Our Ref: R/245/10/NMA

Application for a non-material amendment following a grant of planning permission R/83/10 – Additional window at the side elevation and an amendment to the size and position of the velux window to the rear elevation – The Paddock, 37 Angmering Lane, East Preston

Proposed Ground Floor Plan, Scale 1:100

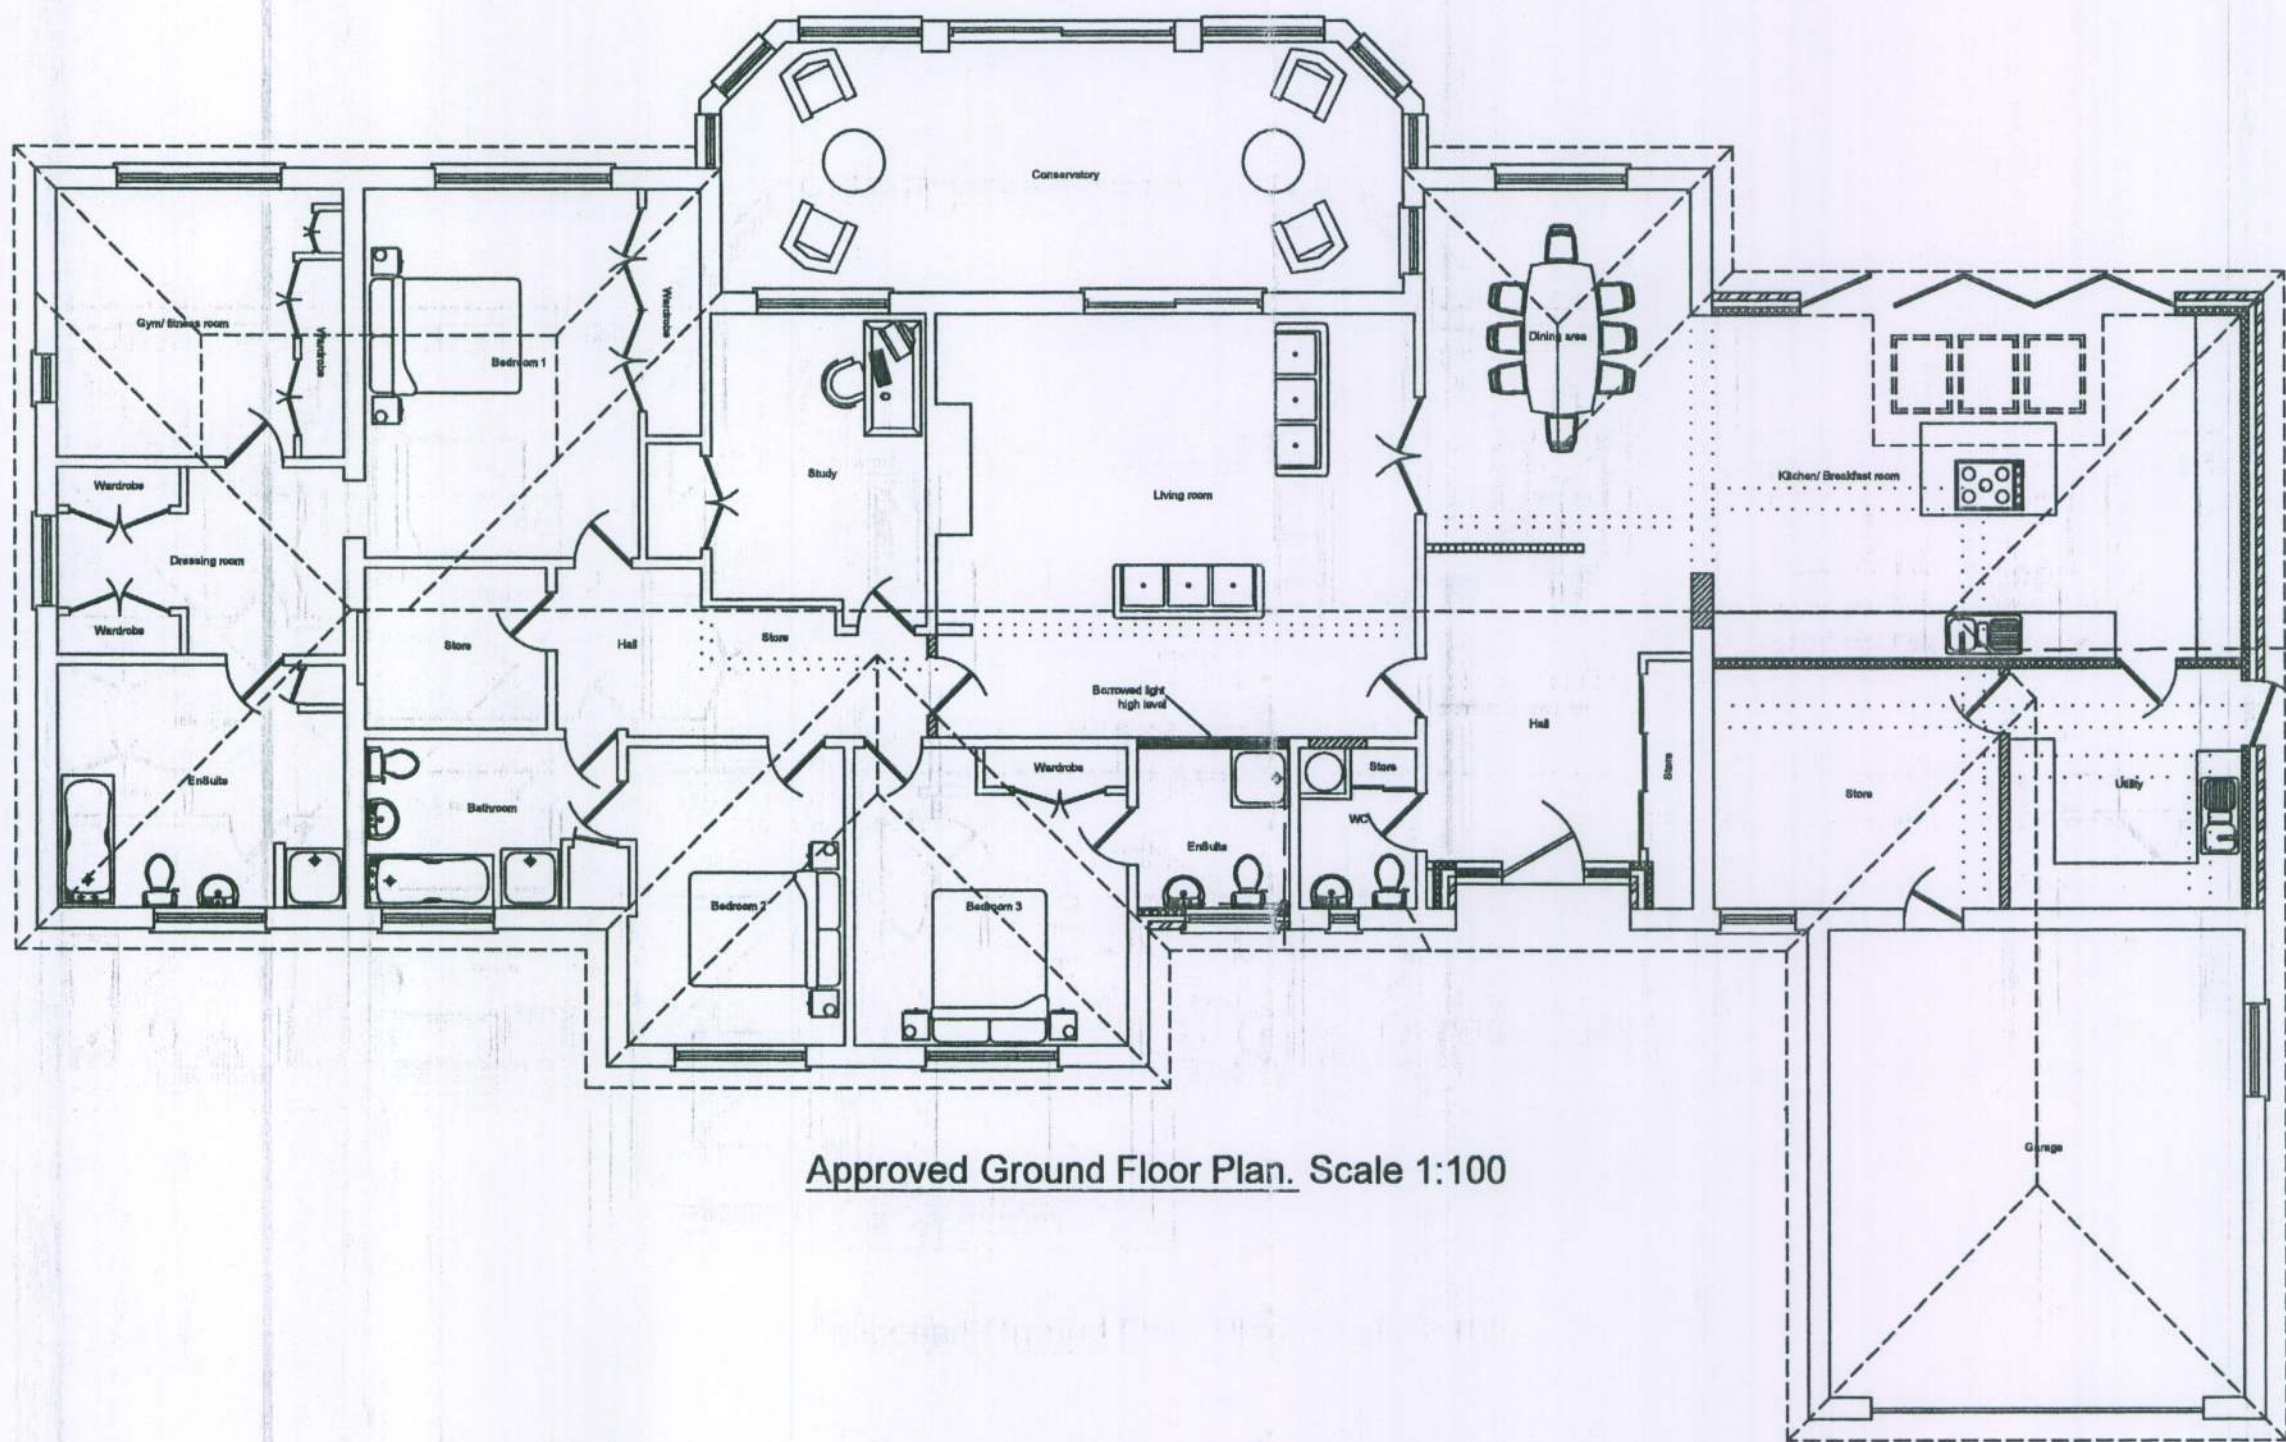
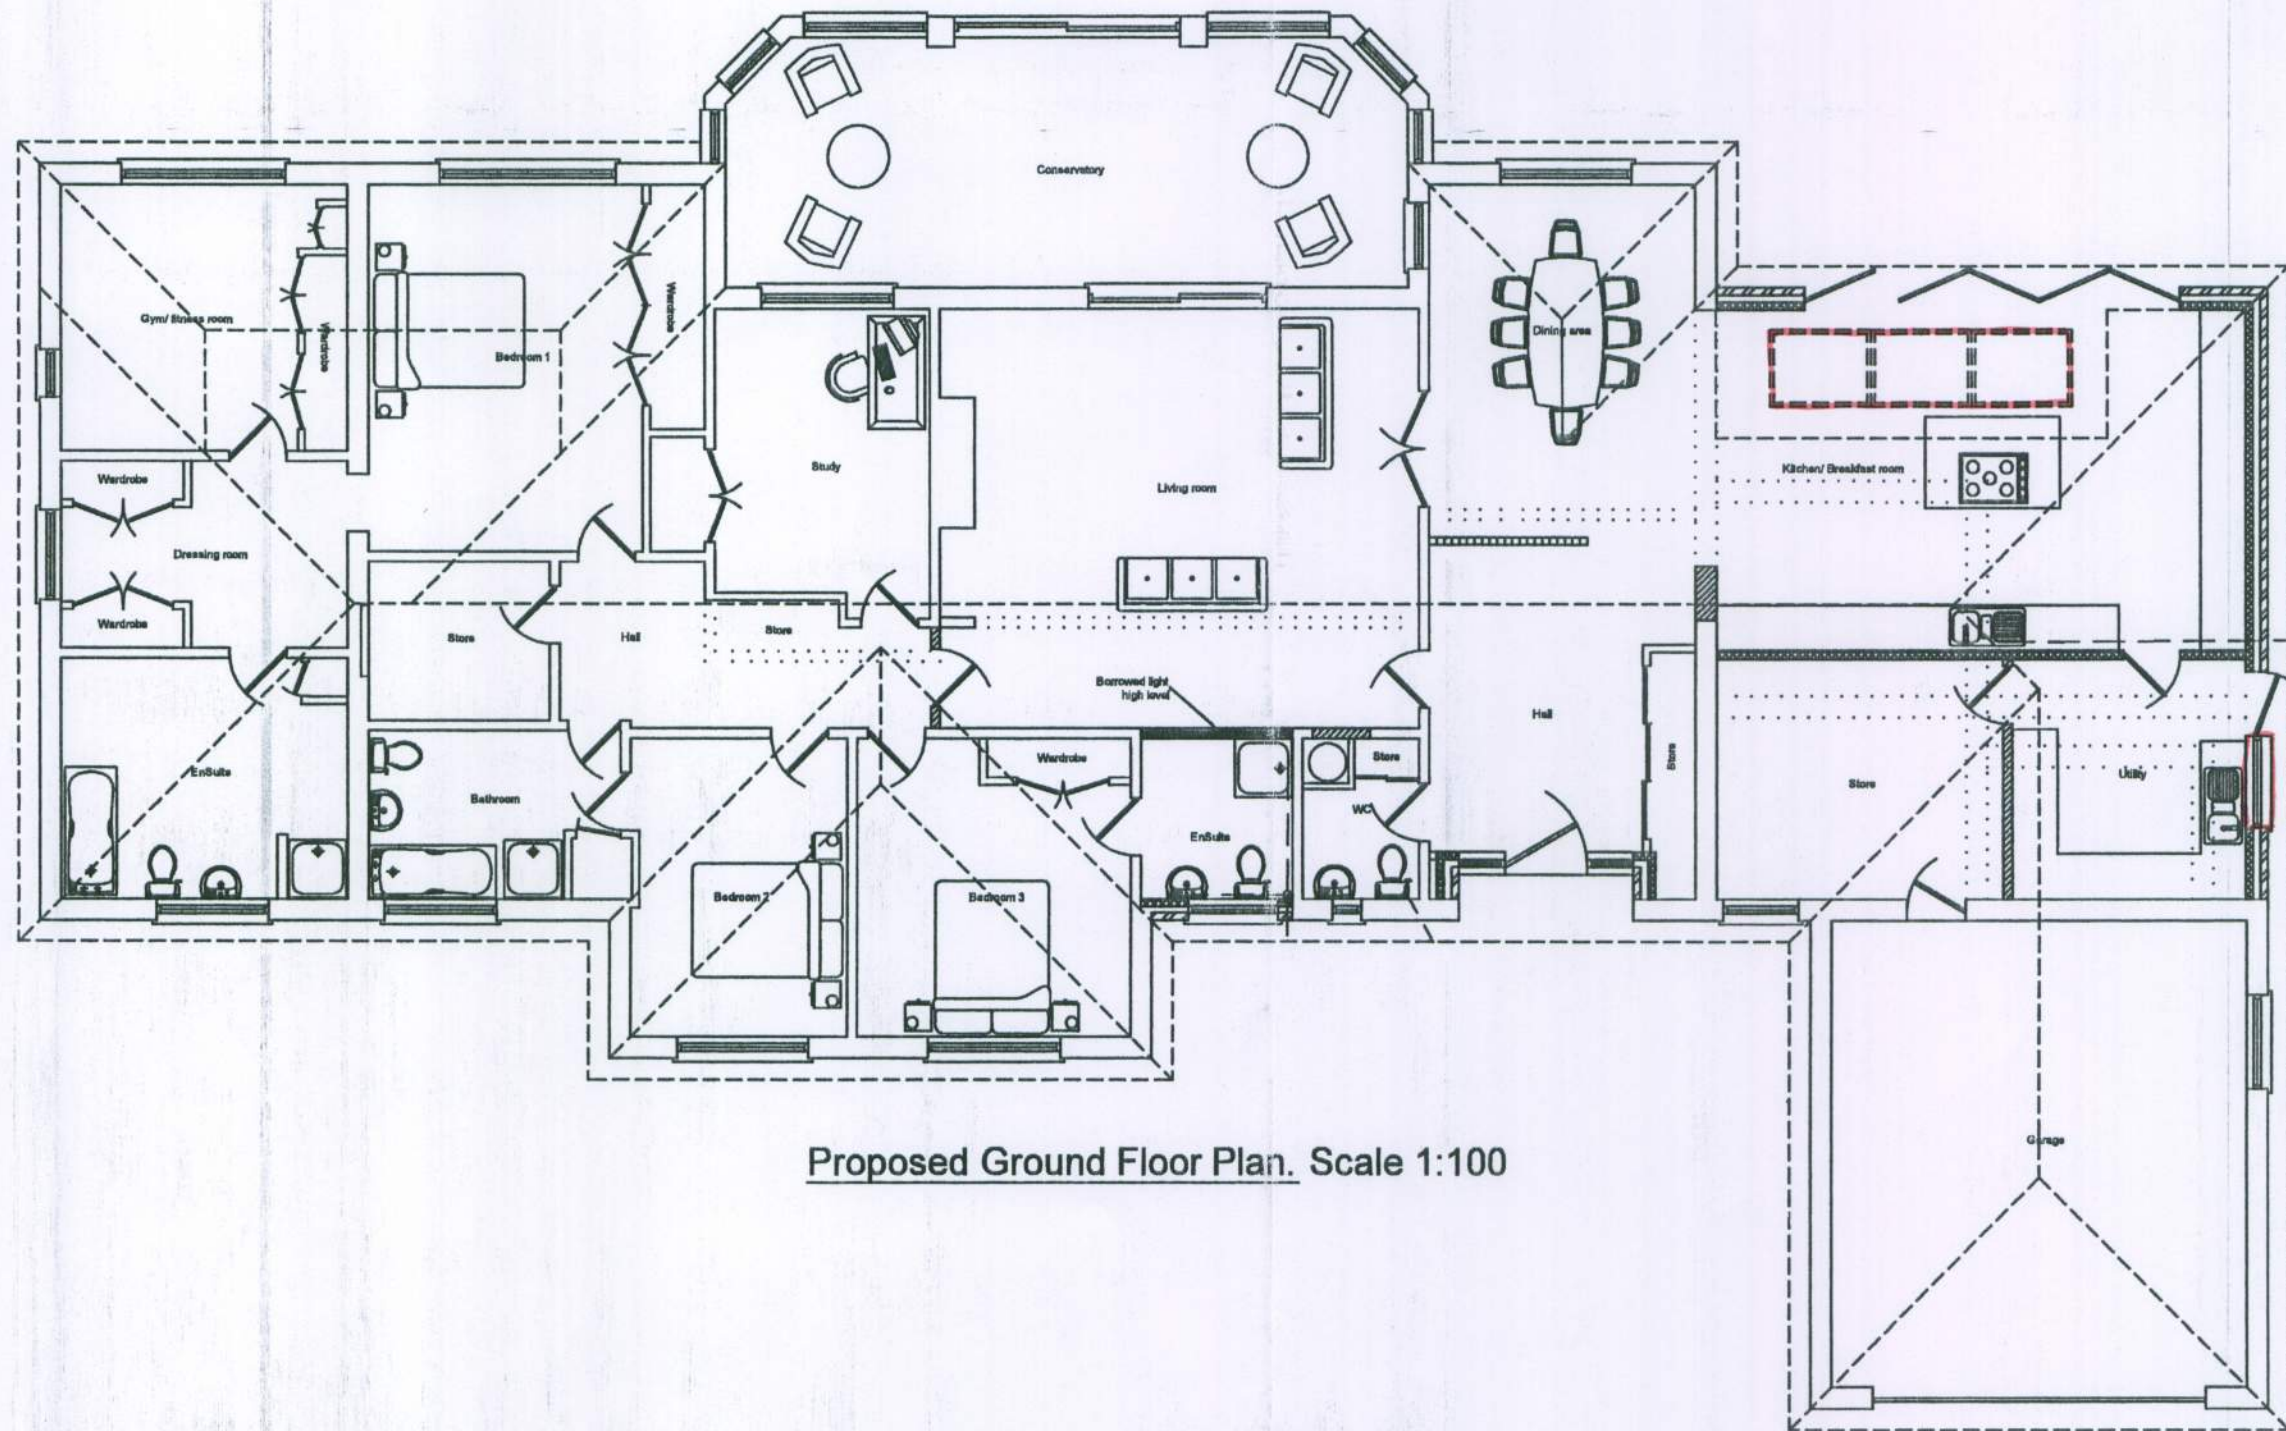
The additional ground floor window on the side elevation and the resized and repositioned rooflights on the rear elevation shown on the submitted plan can be accepted as a Non-Material Amendment.

Please note that these substitute plans therefore become the approved plans for planning application R/83/10.
